One Earth Solar Farm

**Draft-Final Statement of Common Ground with Newark and
Sherwood District Council**

EN010159/APP/8.6.54

December 2025

Drawing Number:  
EN010159/APP/6.20/10.2

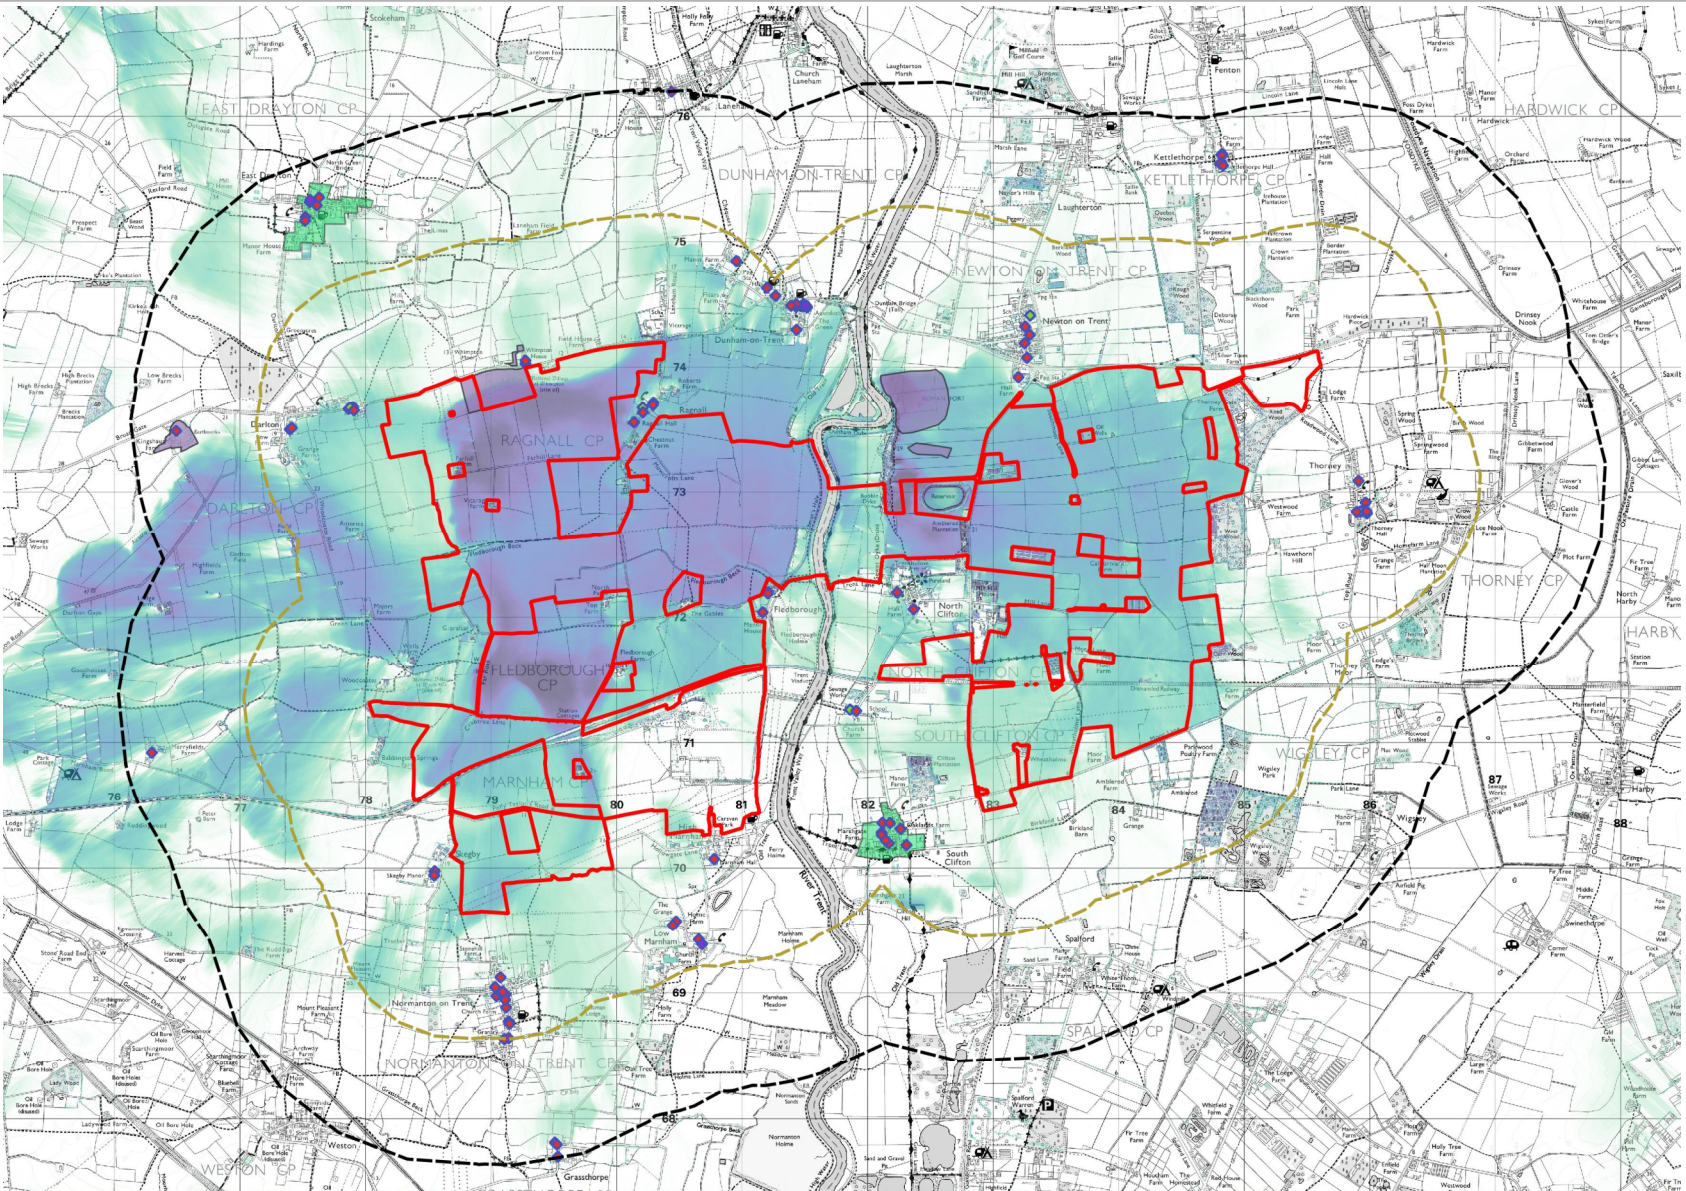
02-04	Perceived impact to Church of St George the Martyr and Church of St Helen	Further consideration required on setting of both assets and further mitigation required – specifically for the impact on Church of St George the Martyr, and Church of St Helen.	<u>Church of St George the Martyr</u> Effects of the Proposed Development on St George the Martyr are located within paragraphs 4.136 – 4.139, page 66 of Technical Appendix 10.3 [APP-128] and paragraphs 10.9.9 and 10.6.98.100 of ES Chapter 10 [APP-039]. <u>St Helen Church</u> This asset has been assessed in ES Chapter 10 (ref. APP-039) at paragraphs 10.6.7 and	Agreed

10.6.126, in paragraph 4.191 of the Technical Appendix [APP-128]. The Zone of Theoretical Visibility mapping [Figure 10.3 (APP-055)], the Proposed Development would hold no visibility. Further detail can be found in the Applicant's Response to Relevant Representations [REP1-075]	
02-05	Ruins of Old Church in Churchyard	Recommendation of further mitigation to protect any views.	This asset has been assessed in ES Chapter 10 (ref. APP-039) at paragraphs 10.6.7 and 10.6.126 and on page 85 of Appendix 10.2 (grouped with other assets in Thorney, as agreed with stakeholders – see Table 10.5 [APP-128]). The Zone of Theoretical Visibility, there would be no impact to the value (significance) of this asset, further mitigation is not required as no harm can feasibly exist which requires screening. Further detail can be found in the Applicant's Response to Relevant Representations [REP1-075]	Agreed
